**Howerton Services, PLLC**  
**License # P-1716**  
3513 Cathedral Bell Road  
Raleigh, NC 27614  
(919) 270-3460

Subject: 125 Ruth Circle  
Fuquay Varina, NC 27526  
Plan Revision Letter  
Harnett County Permit #: BRES2208-0056

Based on the request of the Contractor, 1 item on the plans will be revised. My assessment and recommendations are as follows:

WALL BRACING PLAN

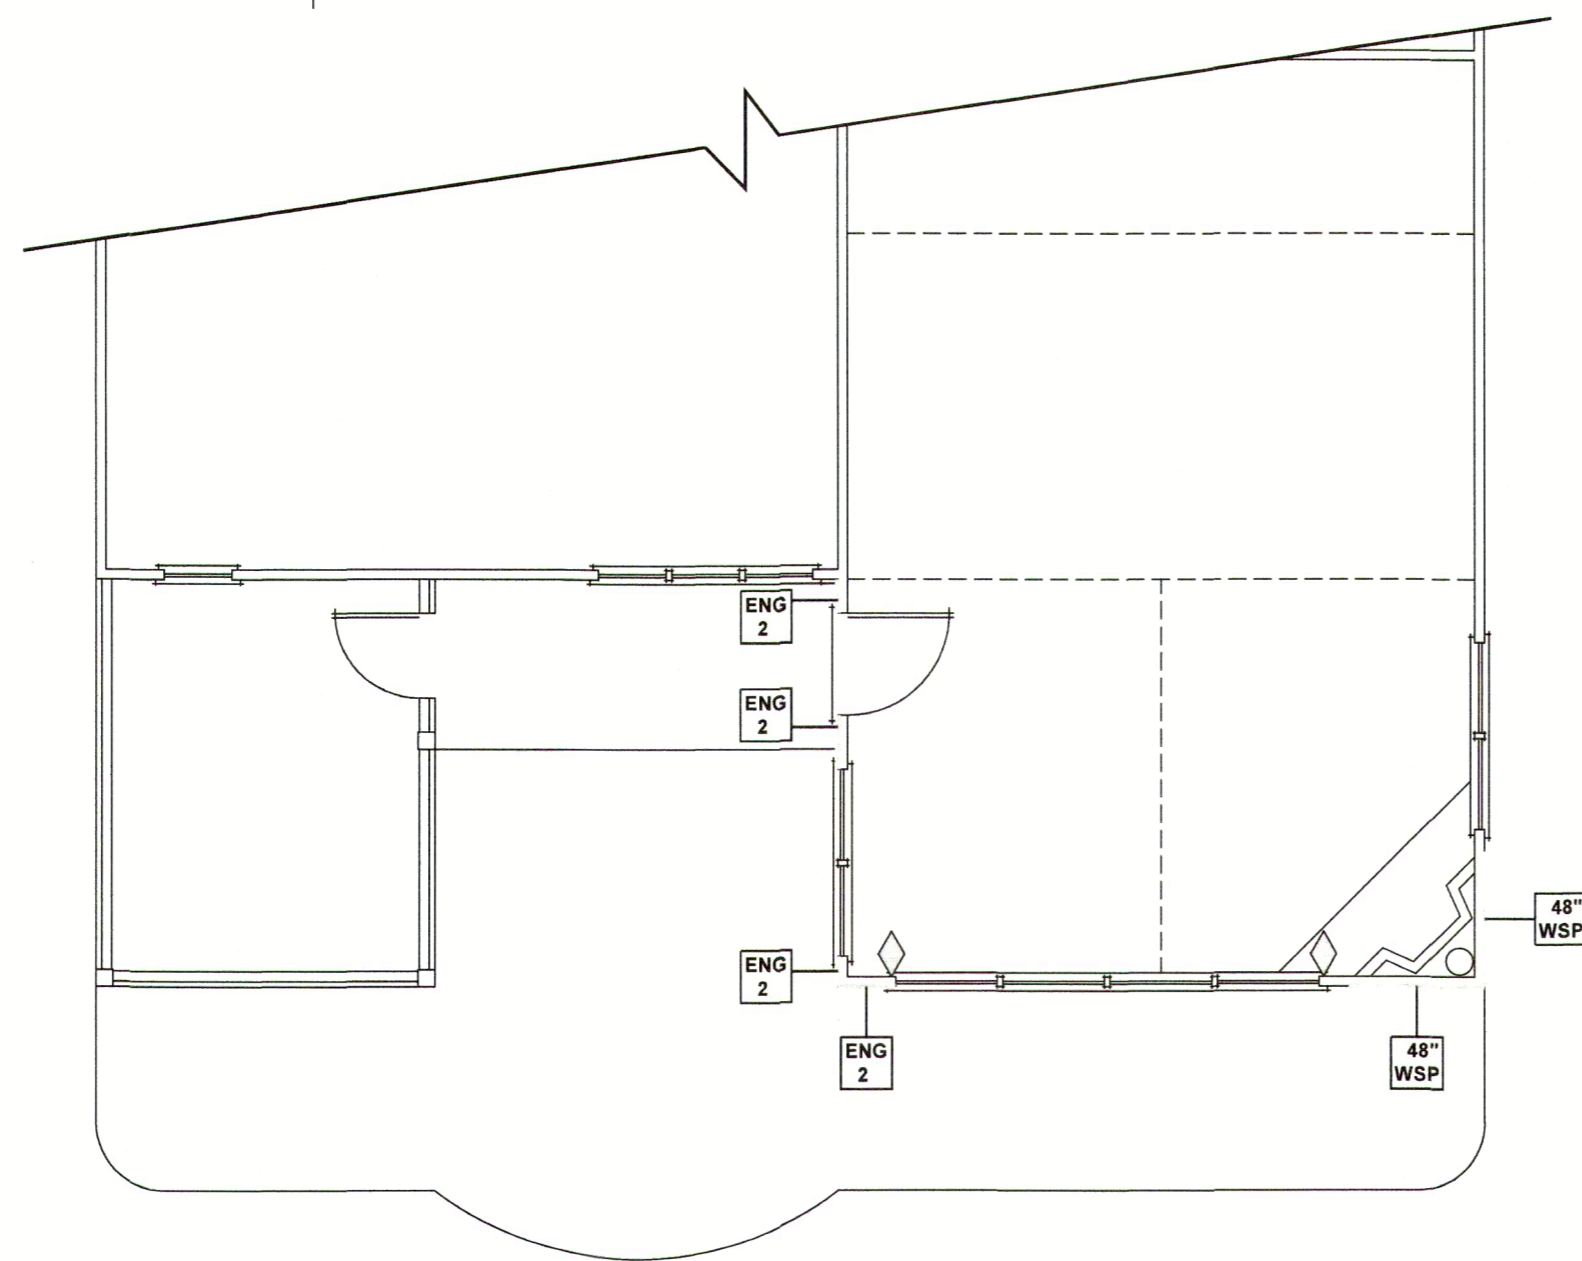
- The original beam was shown as a triple 1 3/4"x 20" LVL with 5 studs on both ends. The Contractor asked to modify the LVL beam from triple 1 3/4"x 20" beam to a double 1 3/4"x 24" LVL. This beam modification is acceptable. Install 3 studs under each end of the new double LVL beam.

The beam modification noted above meets all the requirements of the 2018 North Carolina Building Code for Residences.
